From: Anita Gardner
Sent: 17 December 2018 13:33
To: Planning.Responses
Subject: FW: 1 ARCADE RD REF: LU/310/18/PL

REF: LU/310/18/PL

Dear Anita Gardner,
Re: Proposed Extension and Alterations /1 Arcade Road. Littlehampton.

DWG. NO / 021018 / TP.02

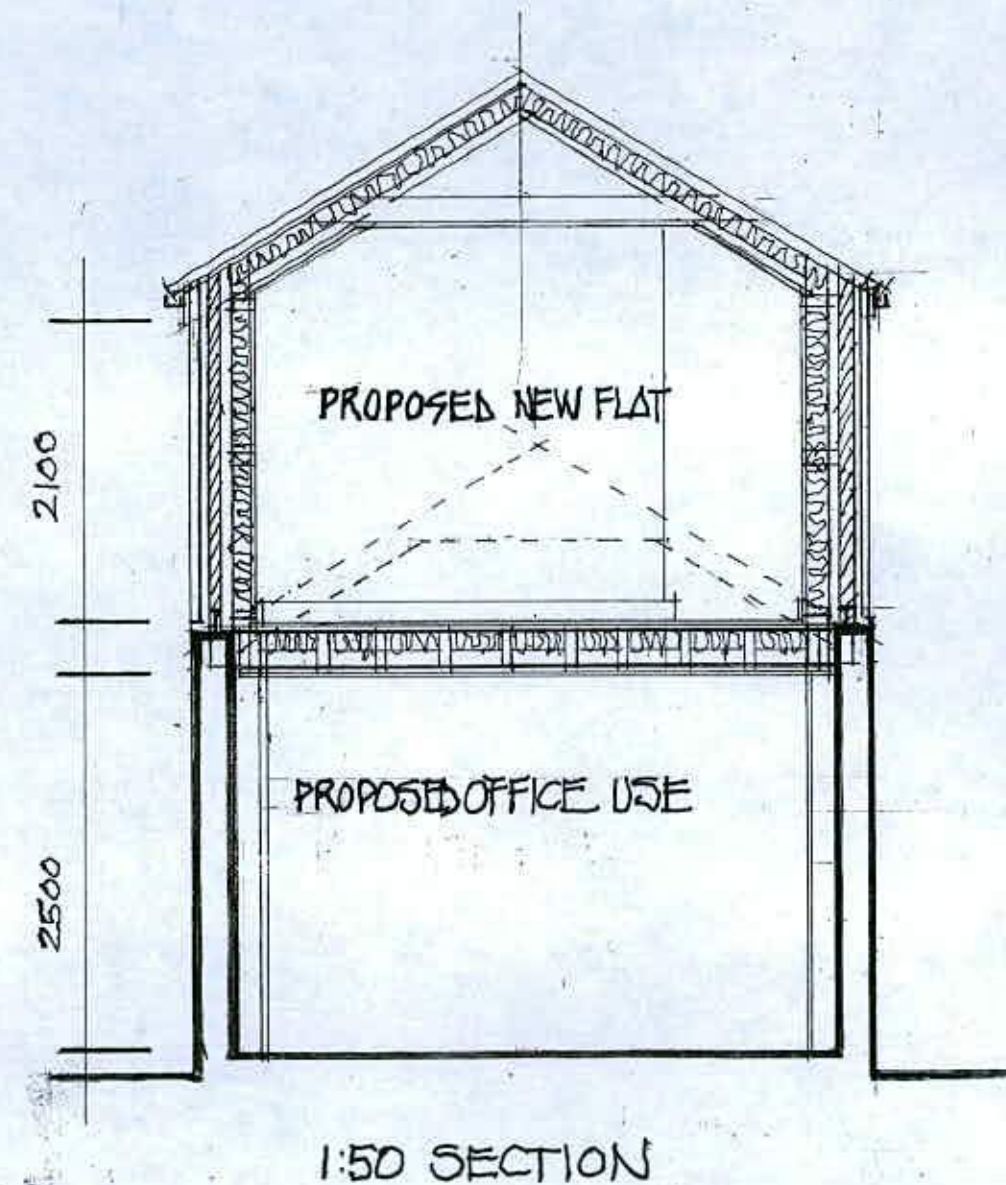
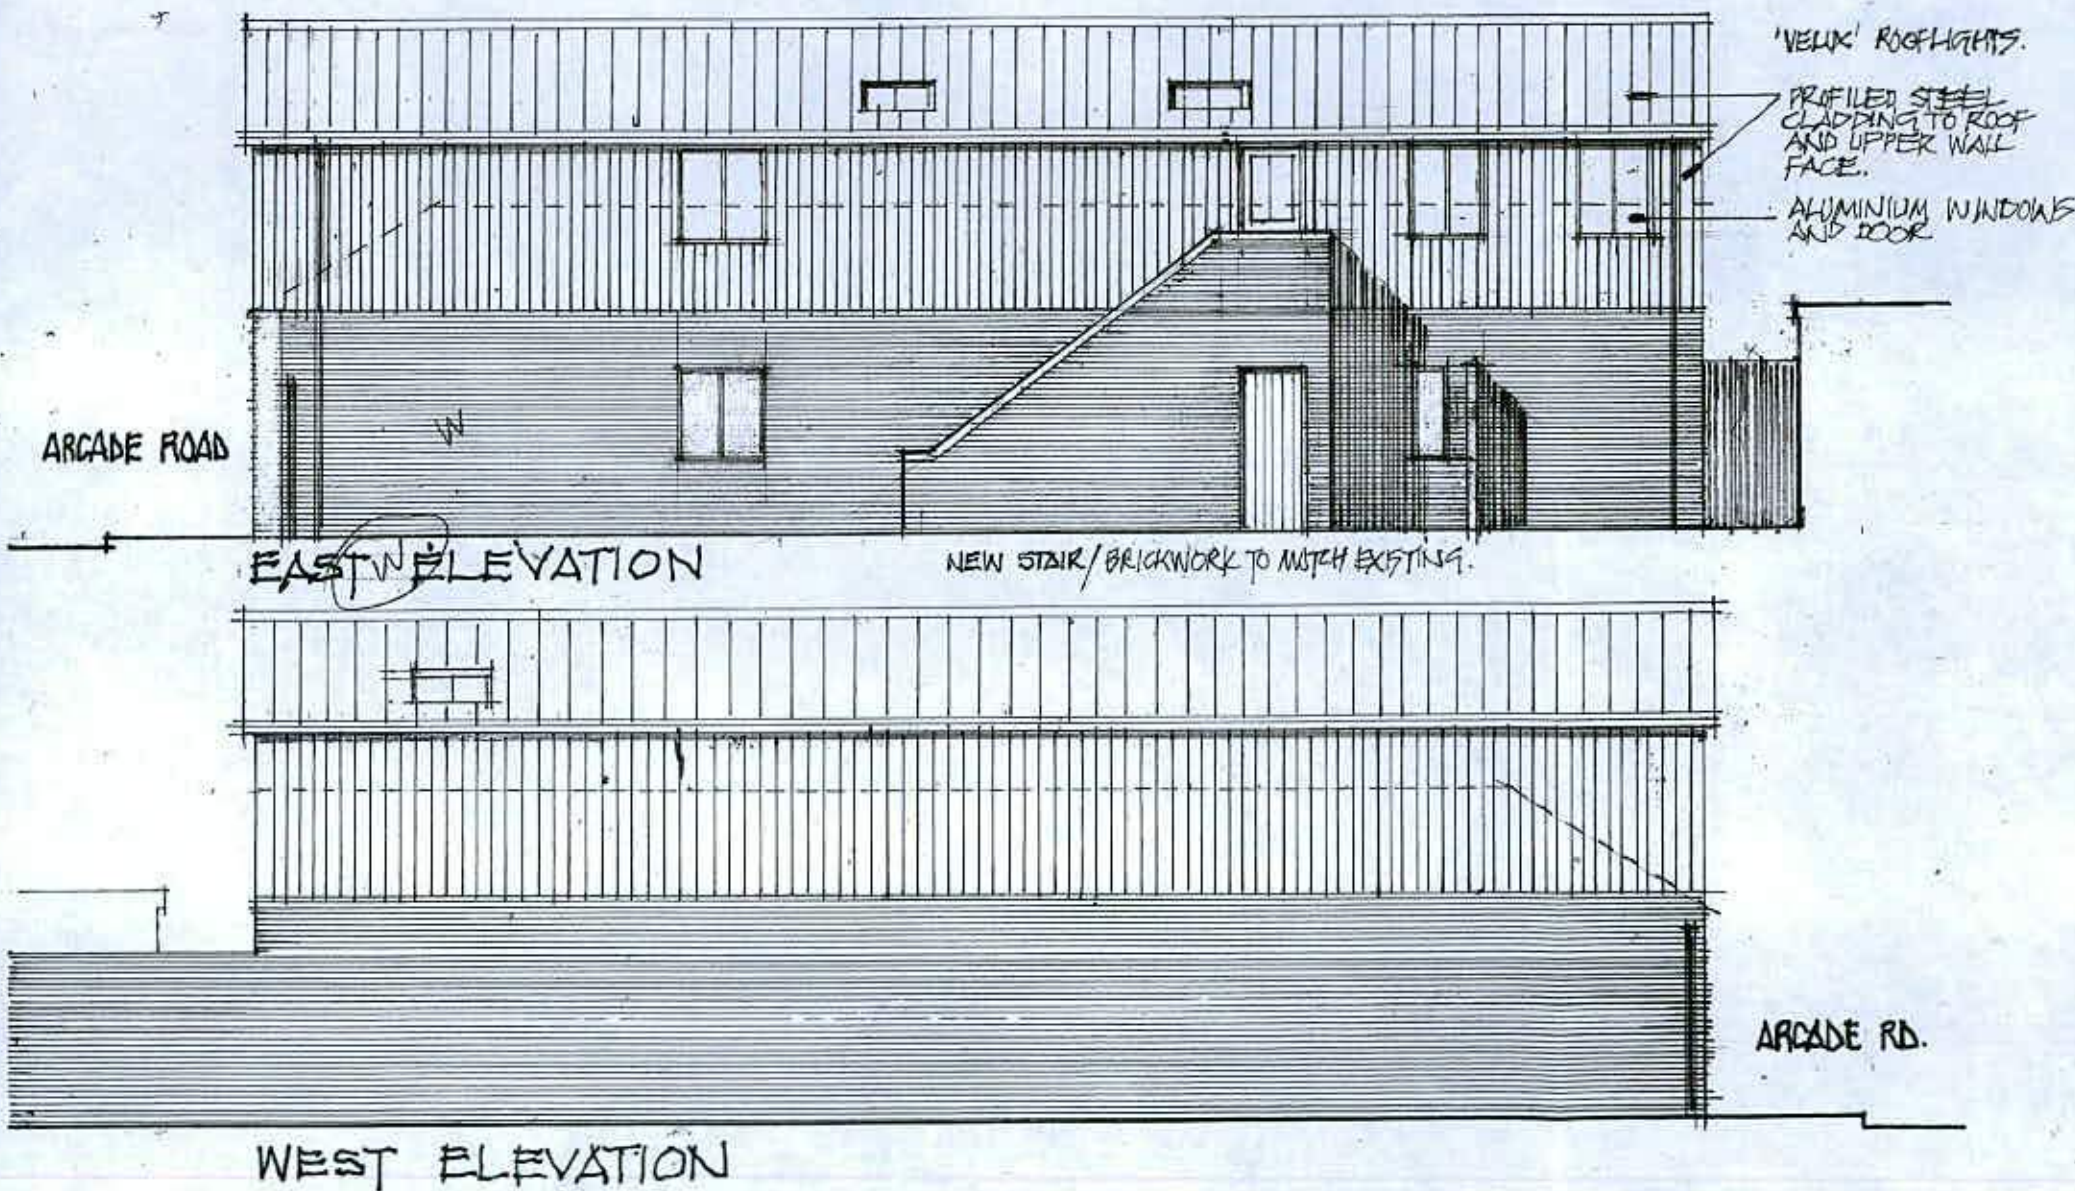
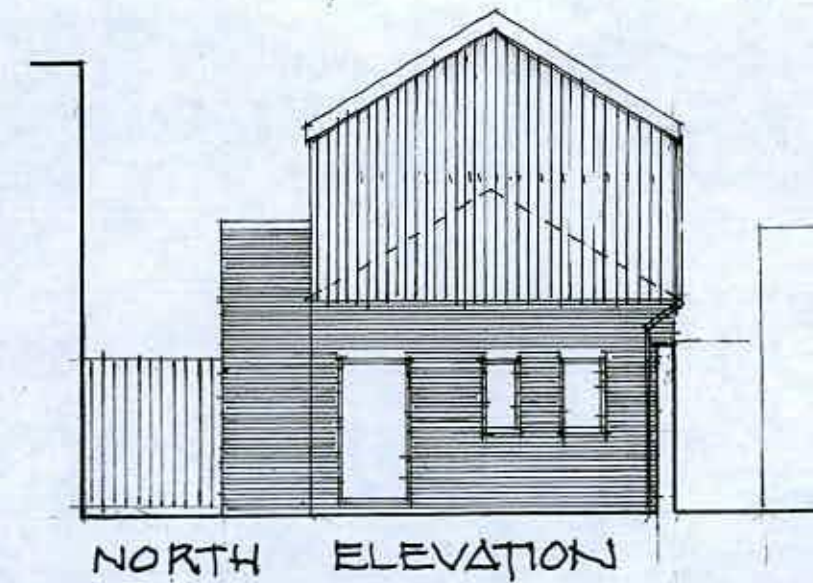
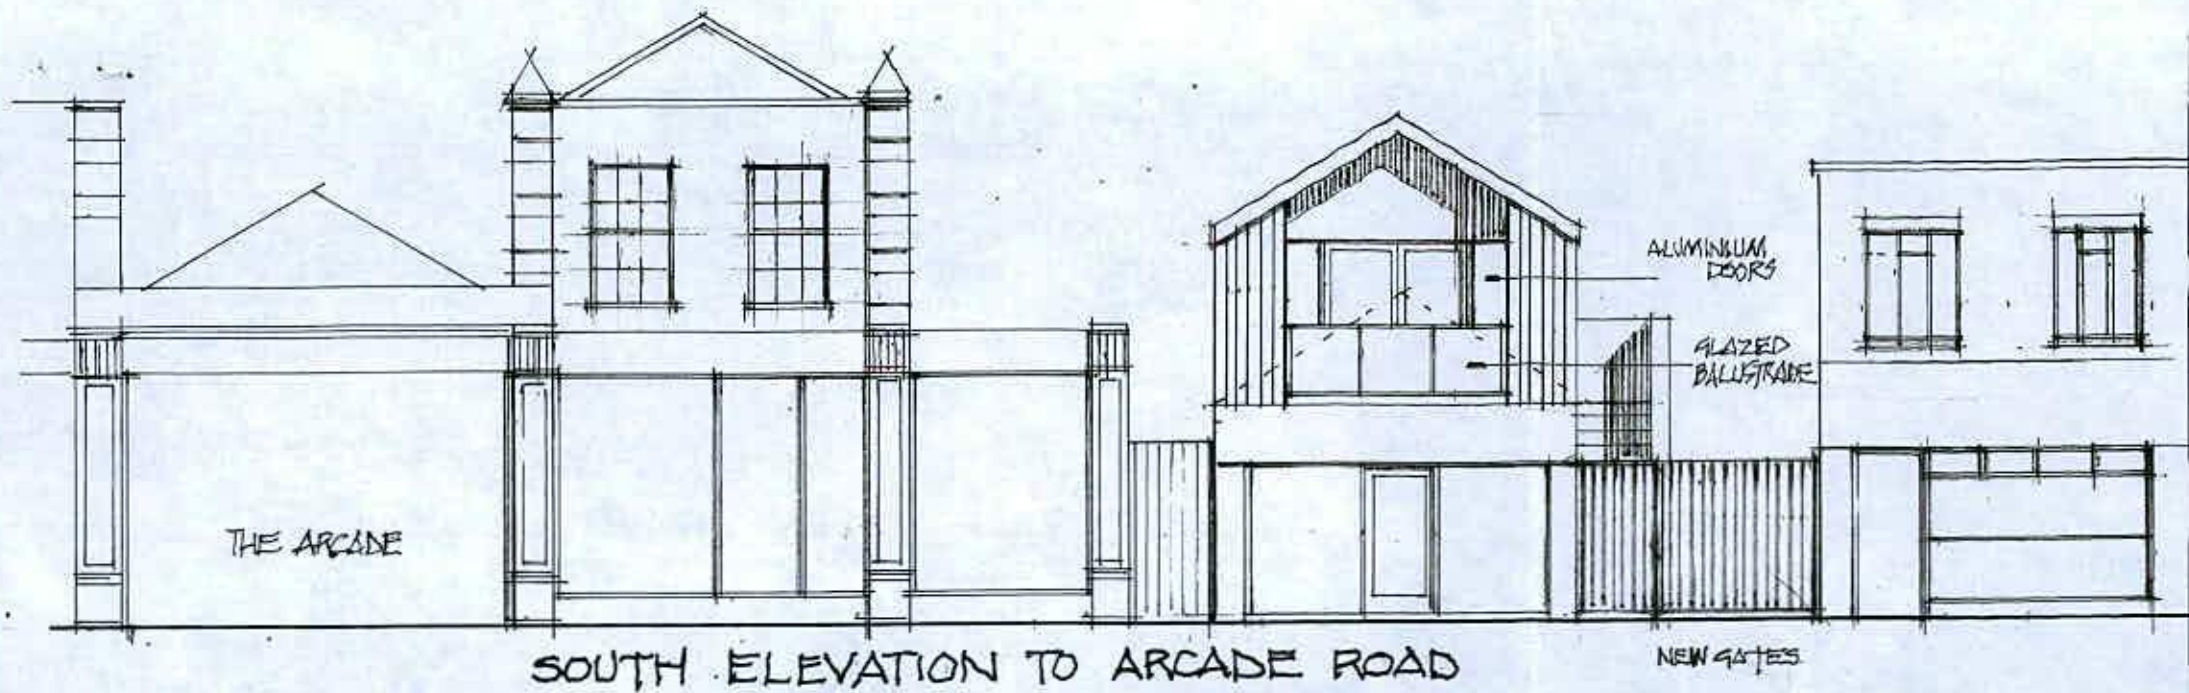
1. It does not state that he recommends either consent or refusal, which I take to mean that he has passed the decision back to you.
2. He refers to the amount of glazing to the street elevation however this is set back within the inset balcony and therefore will barely be visible from the street.
3. Reference is made to the choice of materials. The slate grey cladding does two things, firstly it reflects the slate roofing locally and secondly I believe that the original roof of the existing building was slated given the pitch which is too shallow to have been tiled.
4. He agrees that the change of use of the new upper floor is acceptable and the development could 'enhance' the appearance of the building.
5. I would add that the development will greatly improve the appearance of the existing building and provide some character to the street.
